From: Bloomer, David <David.Bloomer@lancashire.gov.uk>
Sent: 19 March 2018 13:39
To: Stephen Kilmartin
Cc: LHS Customer Service; planning
Subject: app3/2018/0183 Back St Paul's Street Clitheroe

Afternoon Stephen,
The application is to discharge a number of conditions relating to planning permission 2017/0920 .
Of the Conditions that have been submitted for discharge I have identified the following which
have a direct highway impact / implication

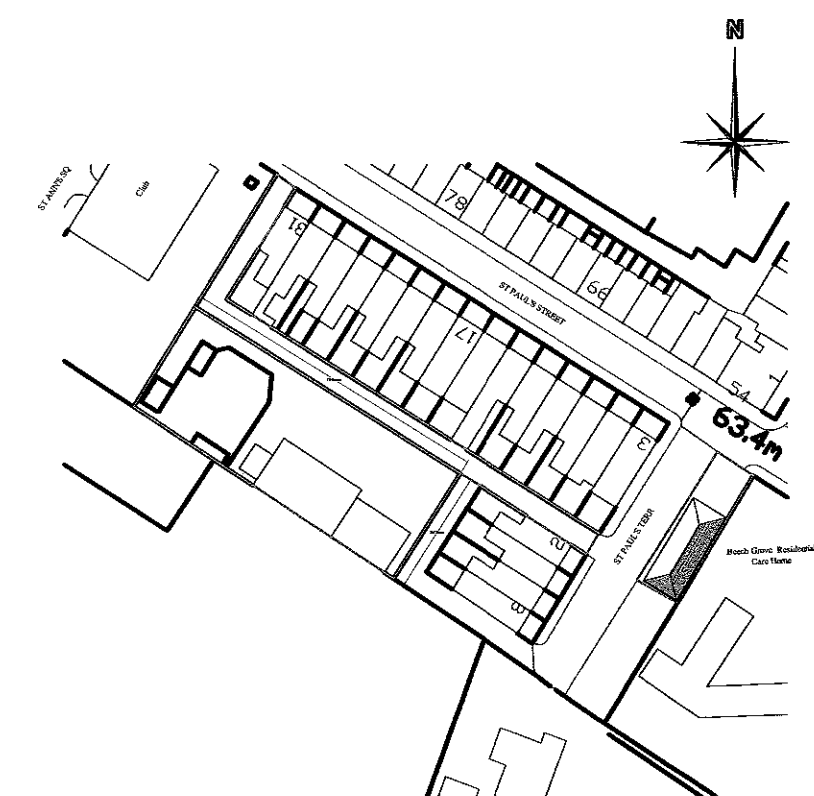
Condition 11 – Roller shutter garage doors. These are stipulated within the planning condition
although the Construction Management Plan does offer the option of an alternative up – over.
Clarification of a commitment to supply the roller shutter type is required.

Condition Discharge (13)

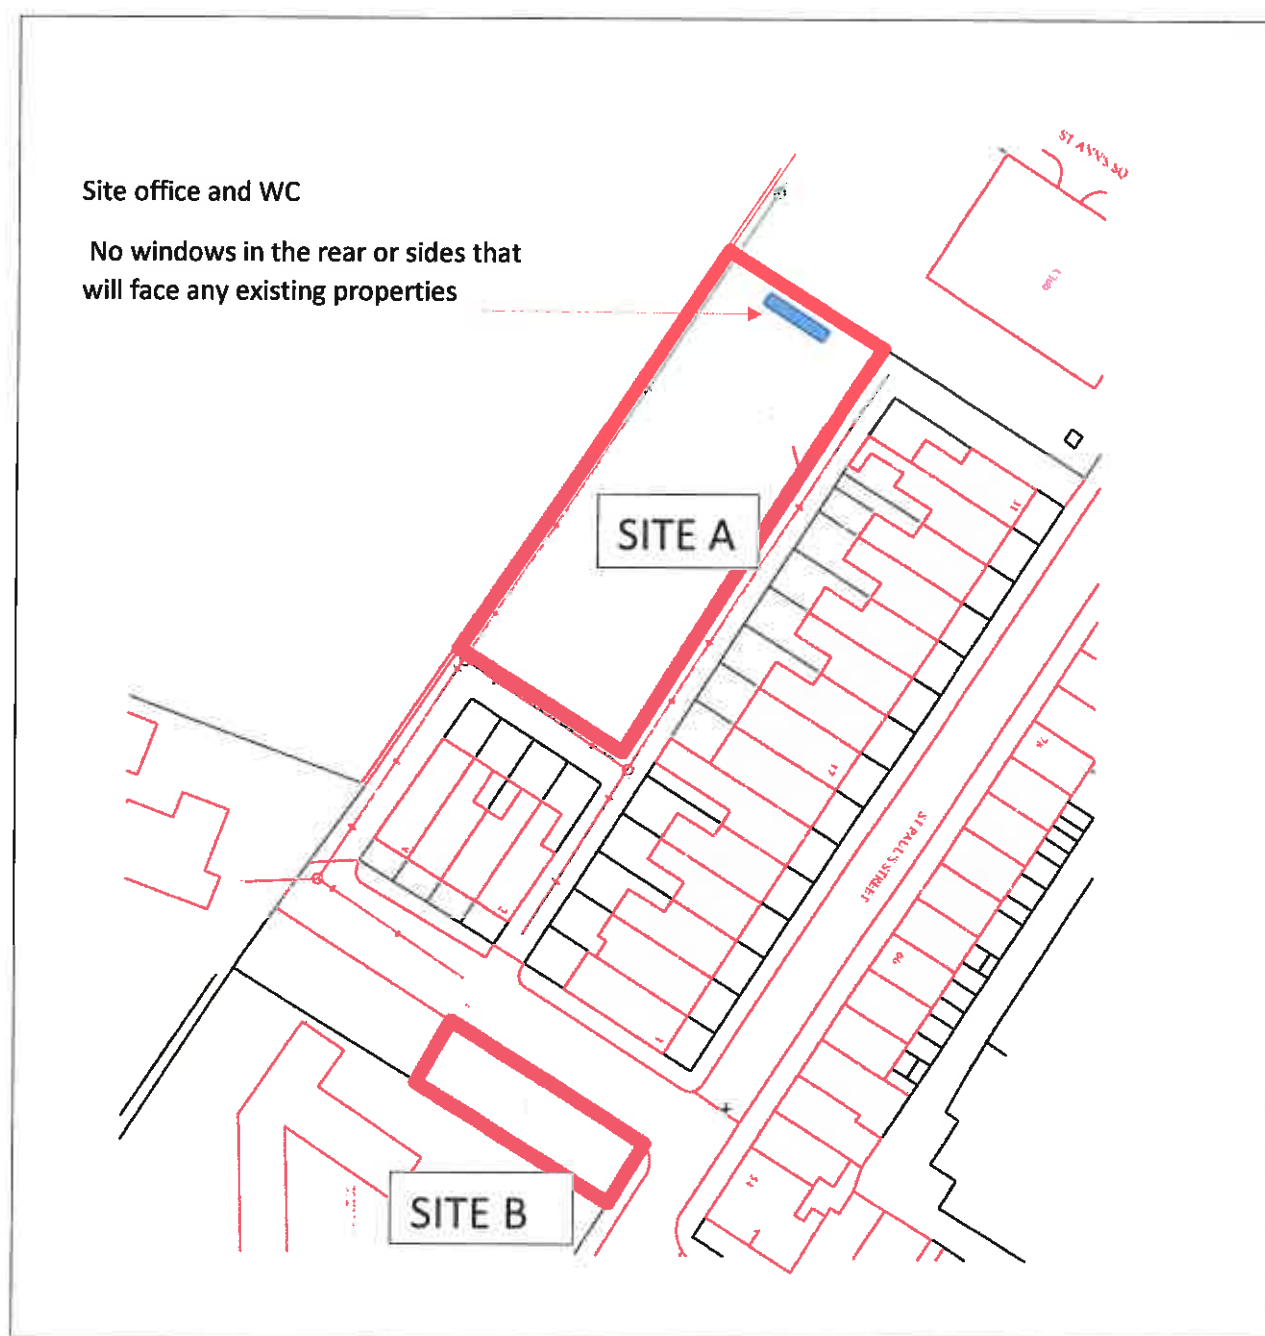
Condition 13 - Construction Management Plan –

A - off street parking facilities are only provided for the site manager (site B) . No mention
is made of the parking arrangements for other staff.

B – no details of how the materials and plant will be unloaded on within the site compound.

C – the internal storage areas of the site compound are not shown

D - not shown

G – Routeing not given

H – Not provided

Further clarification of the deficiencies raised above would need to be provided
